# TIERRA WEST, LLC

April 29, 2024

**RE: 2022031 LOVES SUNPORT BLVD  
ALBUQUERQUE, NEW MEXICO**

CONDITIONS OF APPROVAL –SI-2023-00691

CAUTION

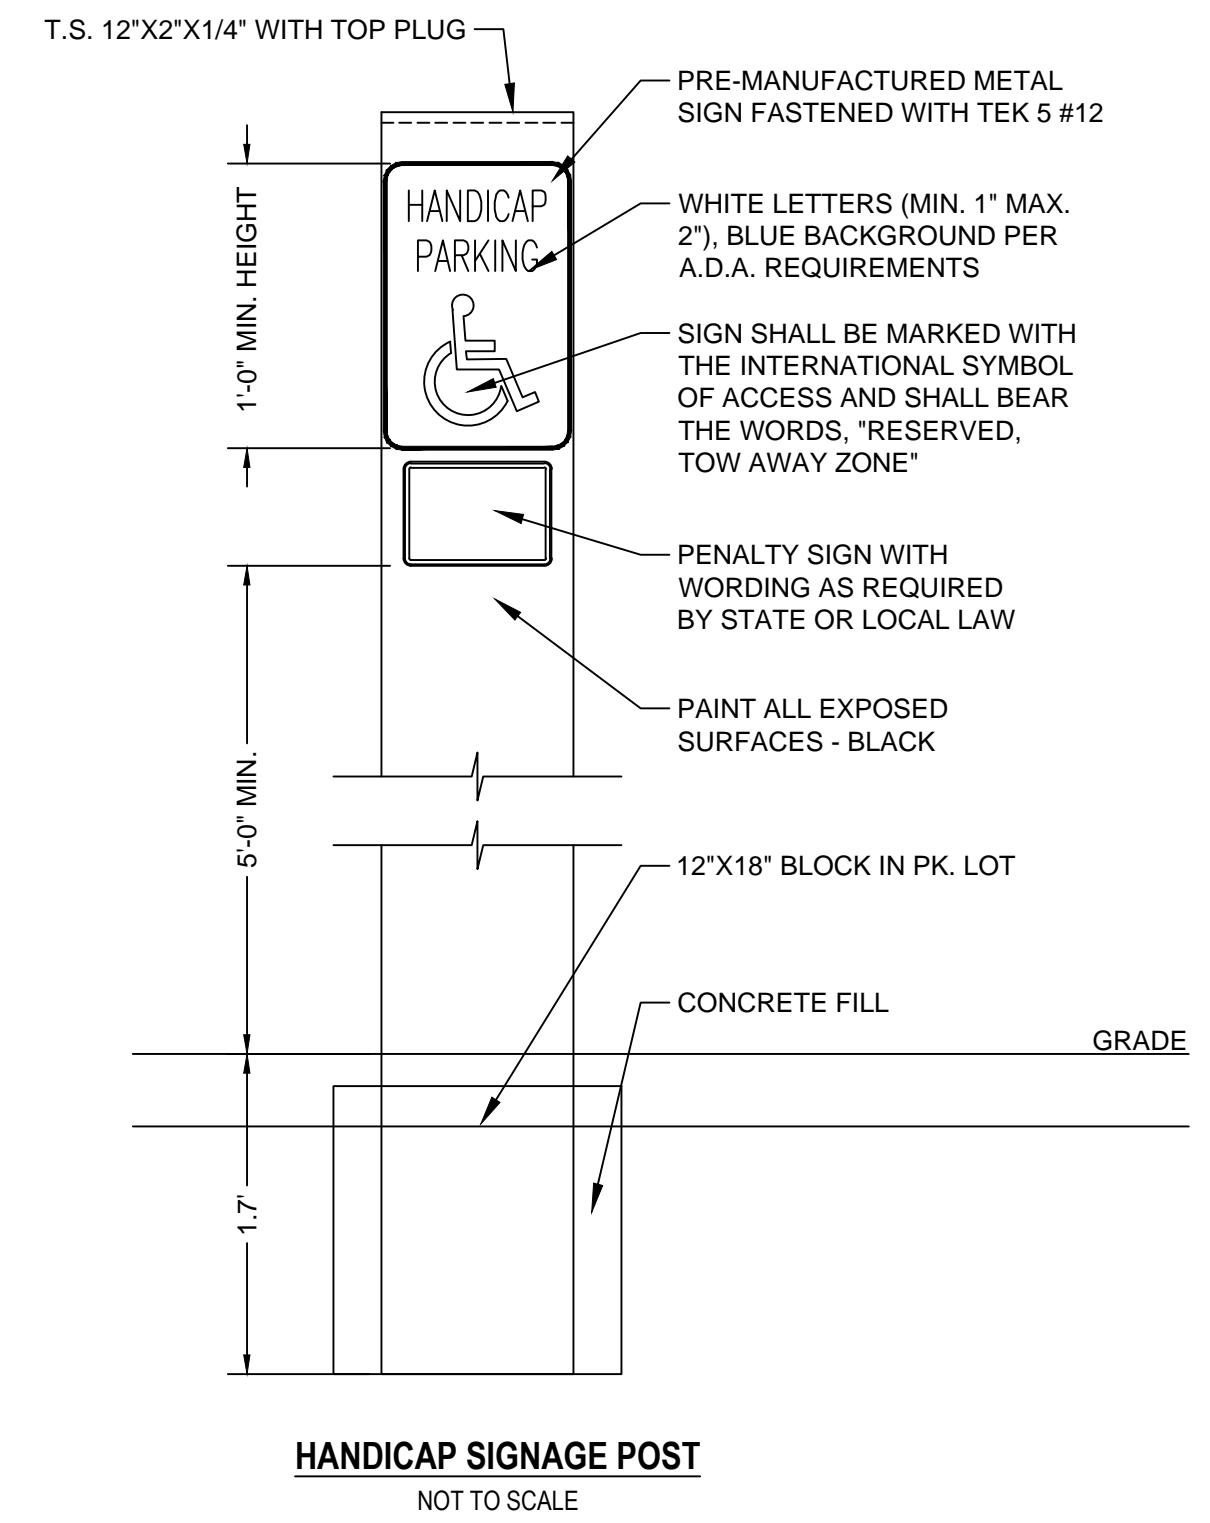
- a. Parking Lot light poles and light details pursuant 4-3(D)(17)(d) shall be included.

**Parking lot light pole detail was added to the Site Plan set (DET-1).**

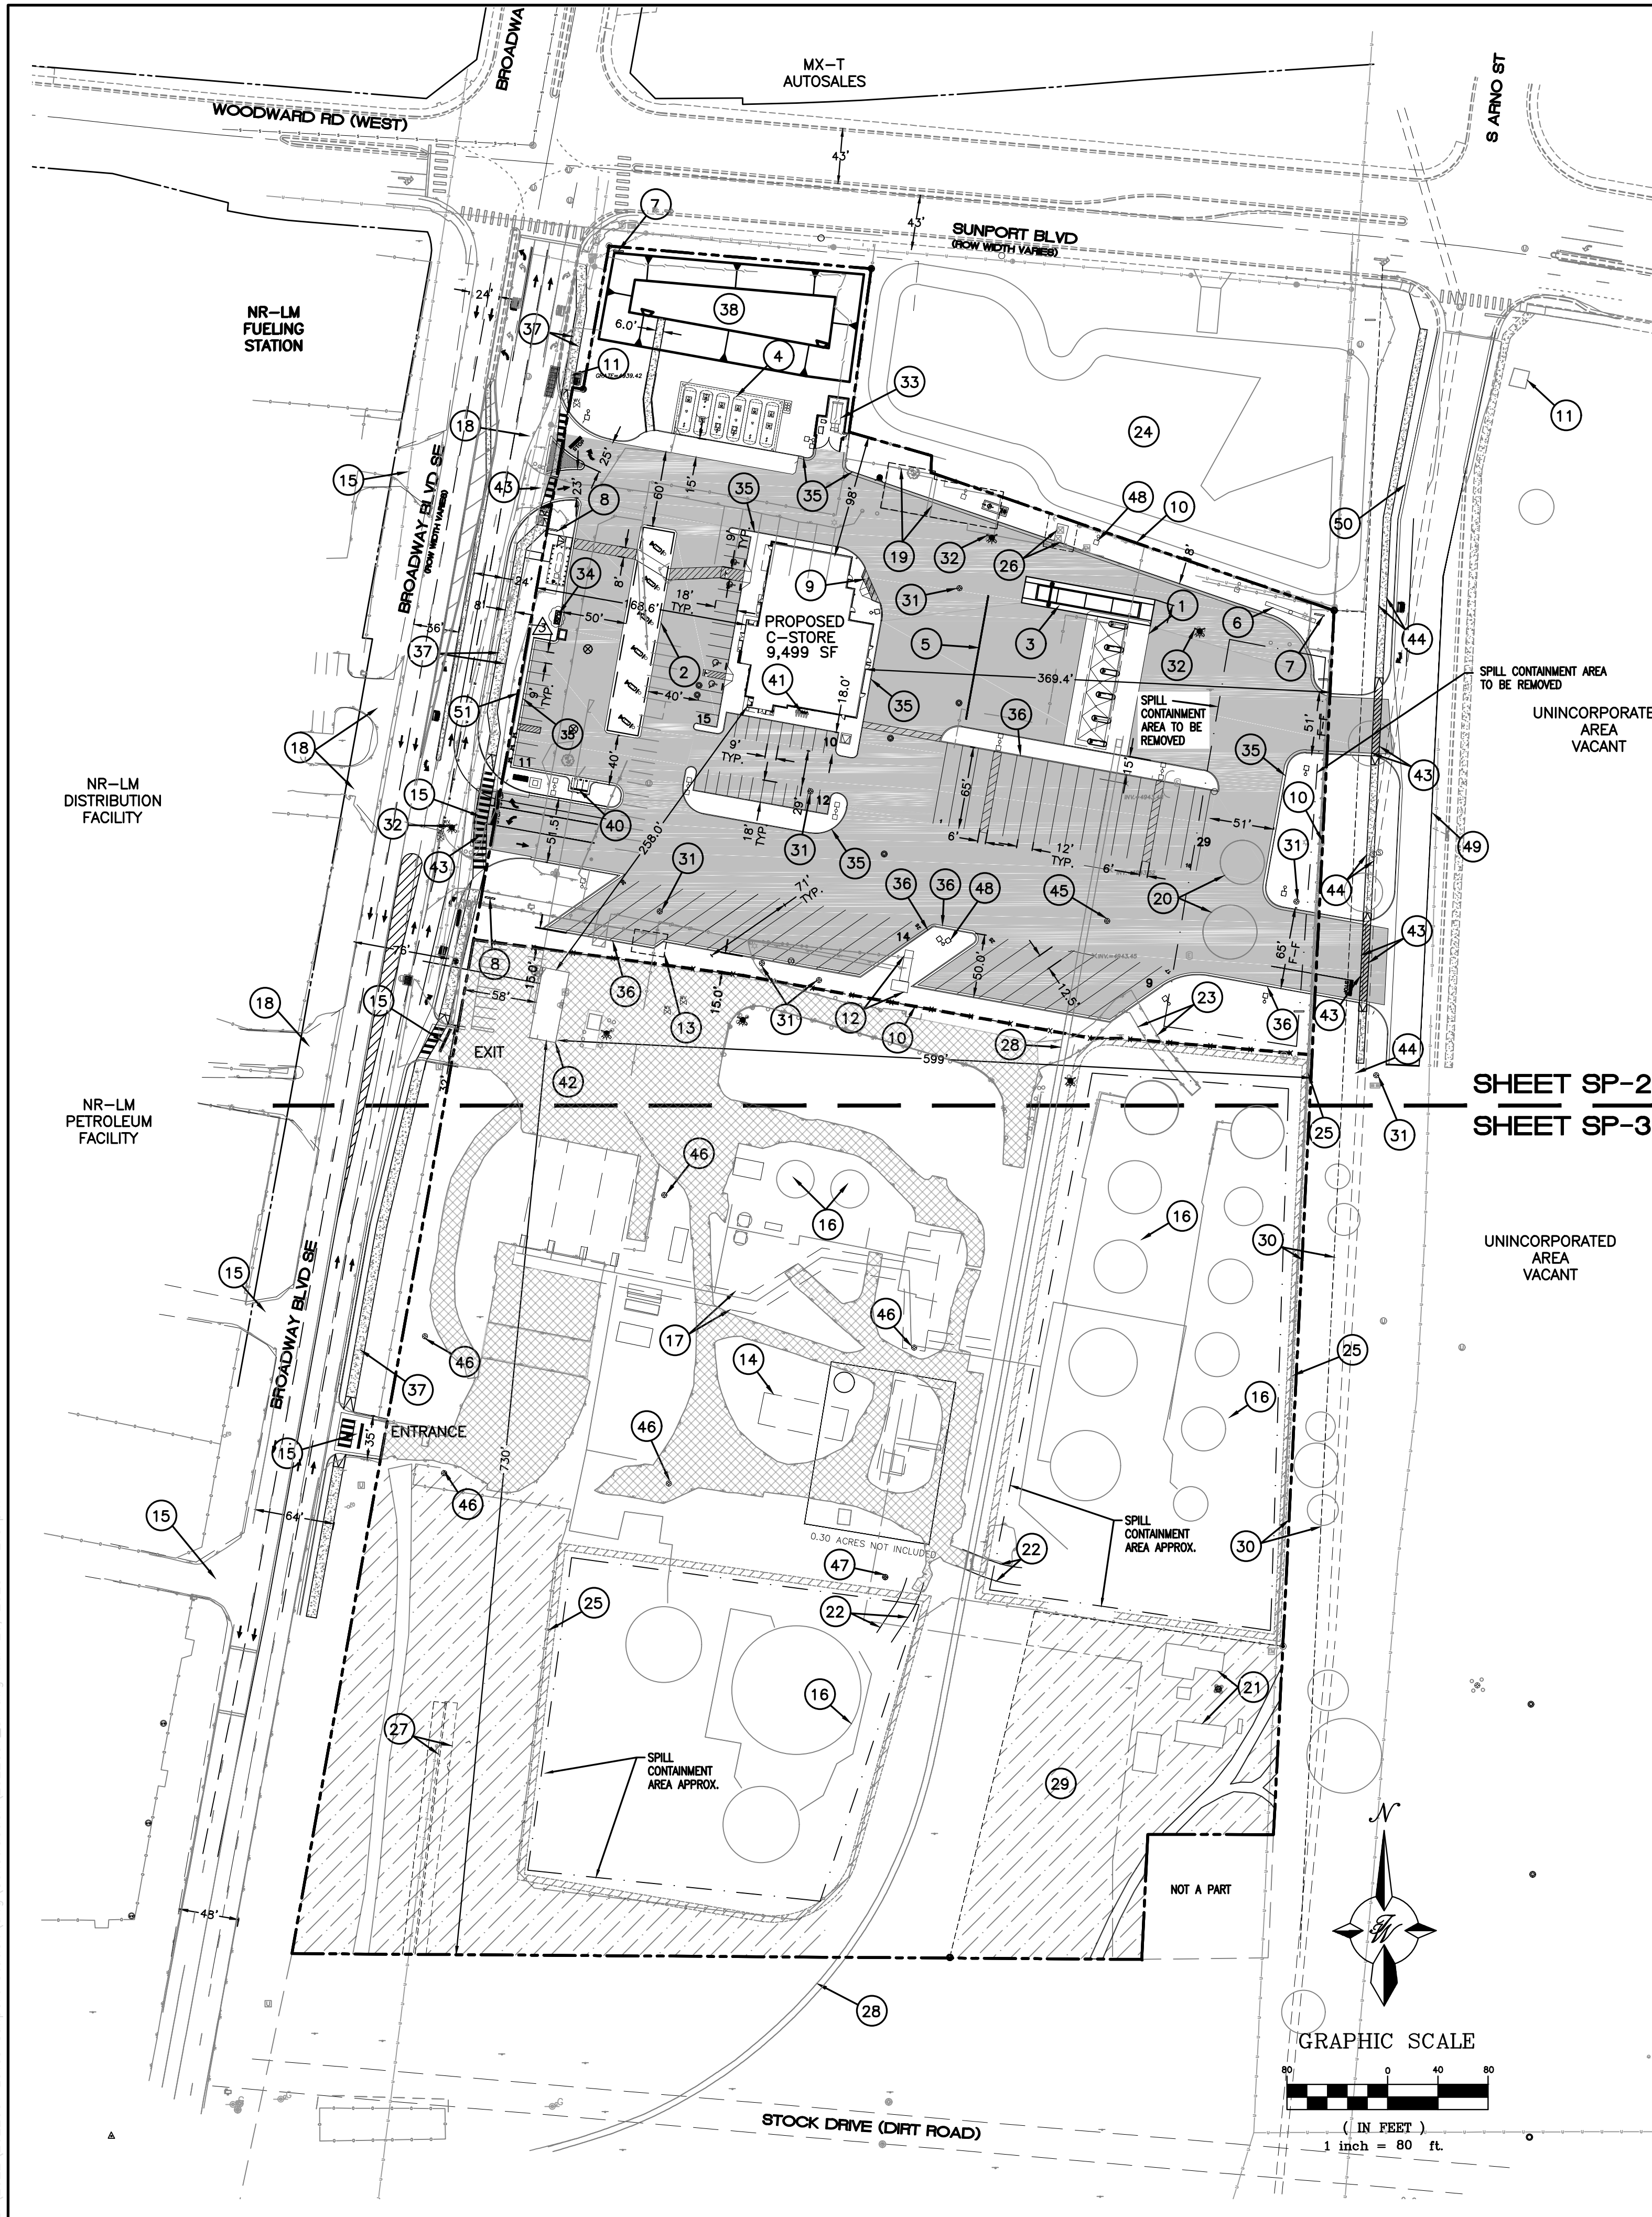
- a. The index to drawings shall include SP3 and all sheets associated with the request.

- b. The 0.30 tract that is excluded in the legal description on the southern portion of the site shall be highlighted and referenced as “not included” on the overall site plan sheet and on the Fueling Depot As-Built site plan sheet 3.

- c. Pursuant to IDO 6-6(N)(2)(f) Any Variances granted that are associated with the Site Plan shall be noted on the approved Site Plan sheet 1 and sign detail sheets.

- c. A note shall be added to the Site Plan stating that Structure and sign materials and any features therein comply with the glare and reflectivity standards per IDO 3-3(D)(2) Reflectivity.

**The index to drawings on SP-1 has been revised to include SP3.**

**The 0.30-acre tract is shown and noted as “not included” on the overall site plan sheet (SP-1) and the Fueling Depot as-built plan sheet (SP-3).**

**The variances granted by EPC are noted on the Site Plan sheet (SP-1) and the sign detail sheet (DET-3).**

**Note #4 added on Sheet SP-1.**

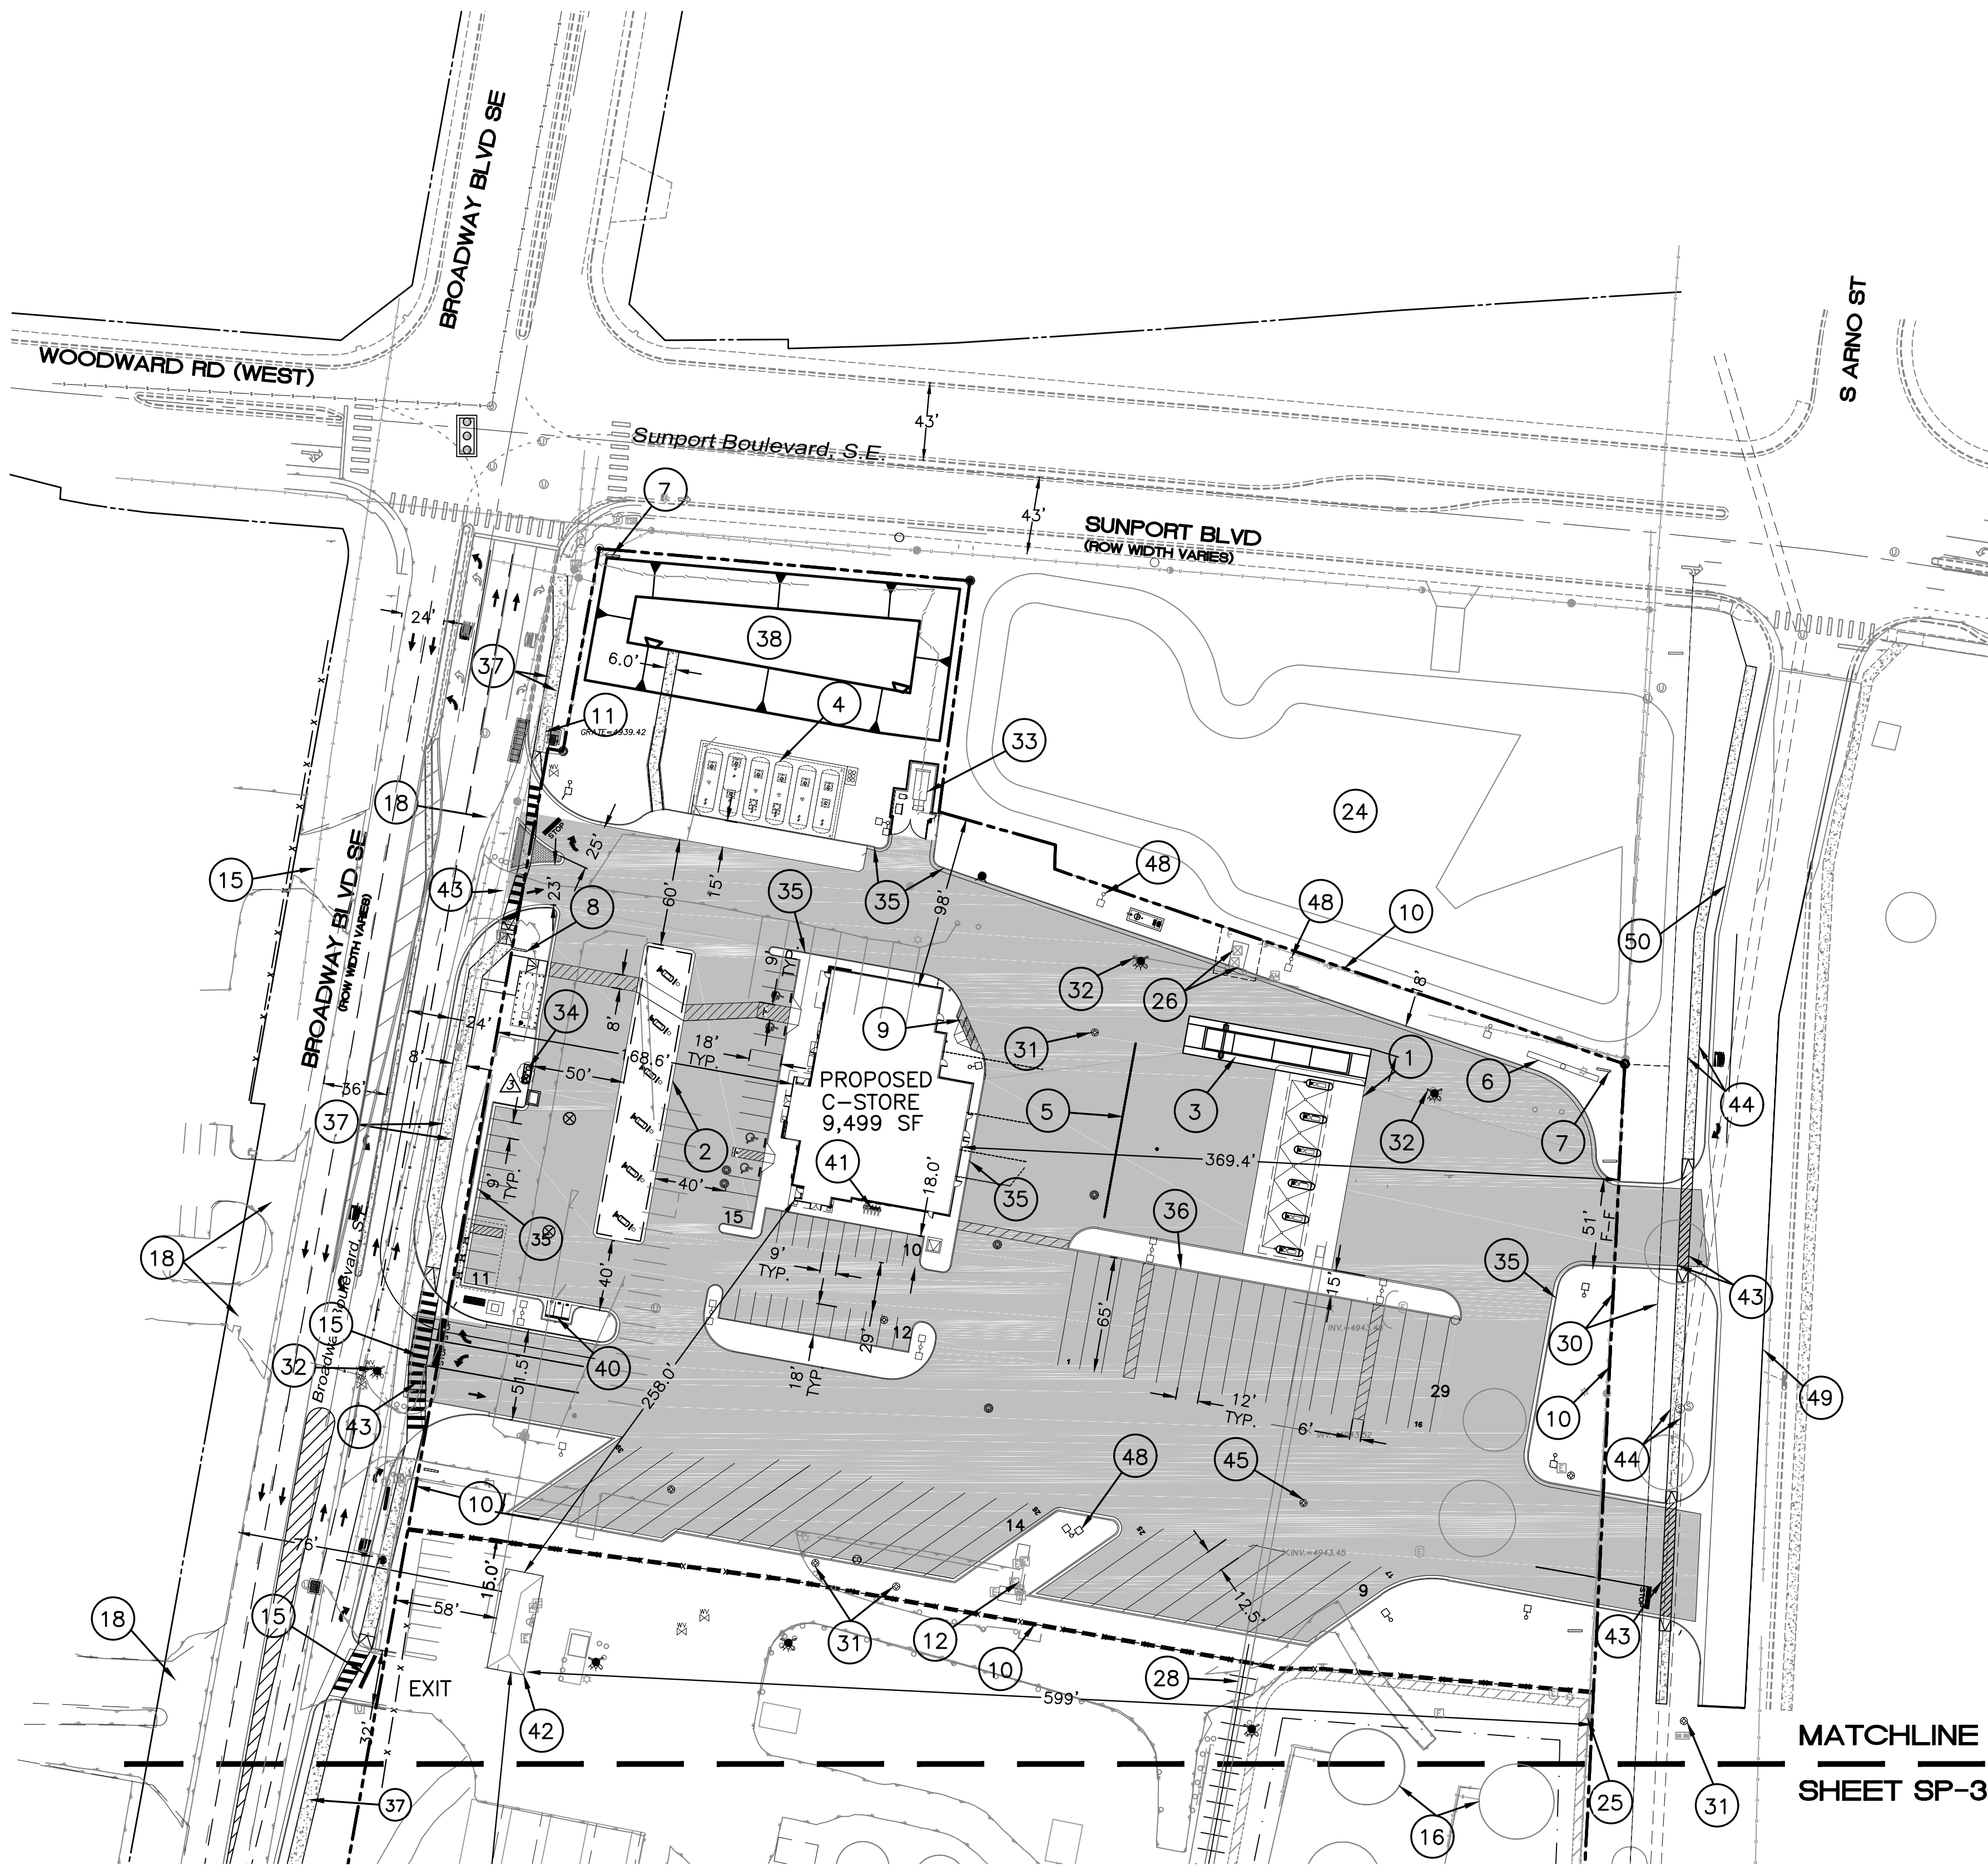
- a. A note stating: "The existing fueling depot on the southern ~15-acre portion of the site is to remain as developed and is included in this request as an As Built Site Plan for clarity and compliance moving forward" shall be added to the sheet.

- b. The 0.30 tract that is excluded in the legal description on the southern portion of the site shall be highlighted and referenced as "not included" on the overall site plan sheet and on the Fueling Depot As Built site plan sheet.

- c. The title of Site Plan sheet 3 for the Fueling depot shall be changed to "As built Site Plan.

**Note added to SP-3.**

**The 0.30-acre tract is shown and noted as "not included" on the overall site plan sheet SP-1 and the Fueling Depot as-built plan sheet SP-3.**

**The sheet 3 Site Plan (SP-3) for the Fueling depot was changed to "As Built Site Plan".**

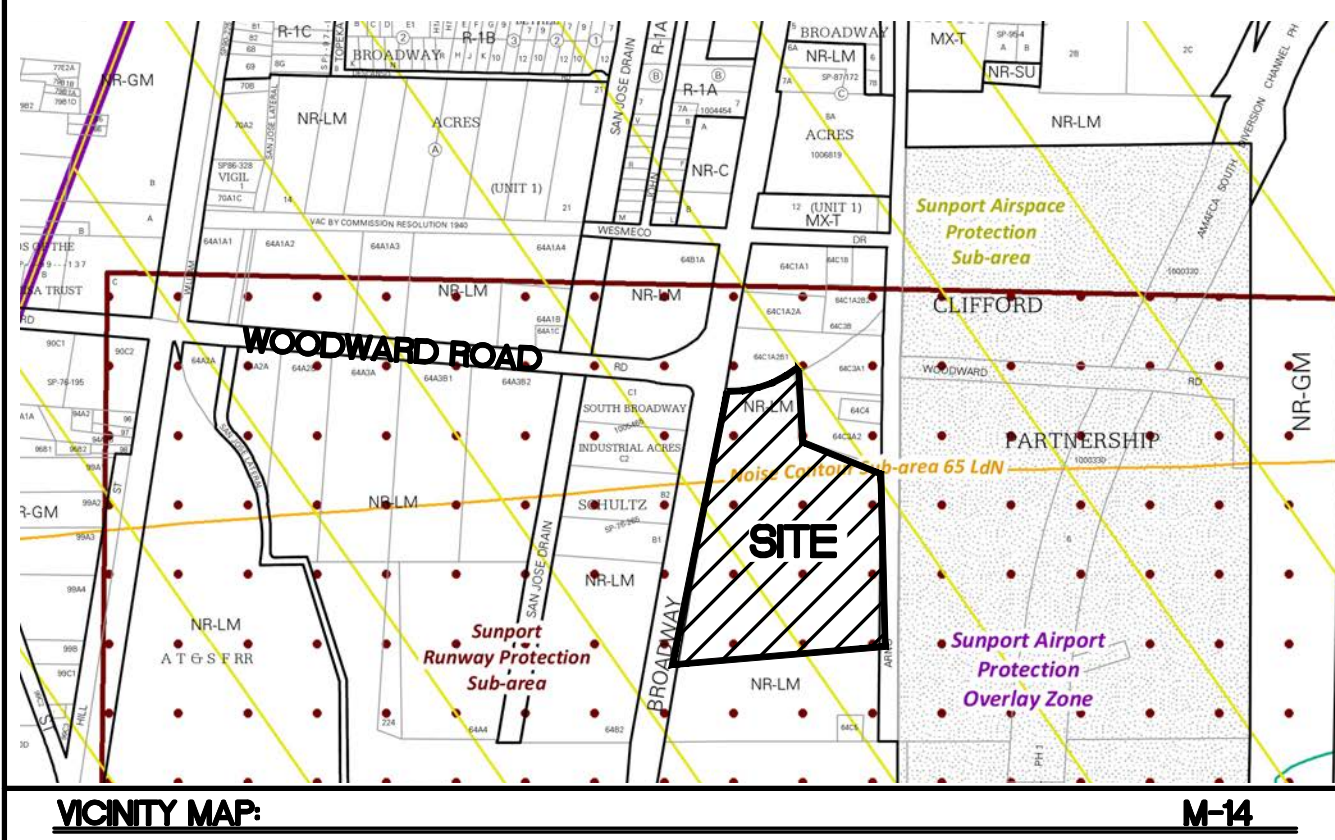
- b. A note shall be added under parking data stating that it the General Retail Small use is incidental to Light Vehicle Fueling.

**Note added on SP-2.**
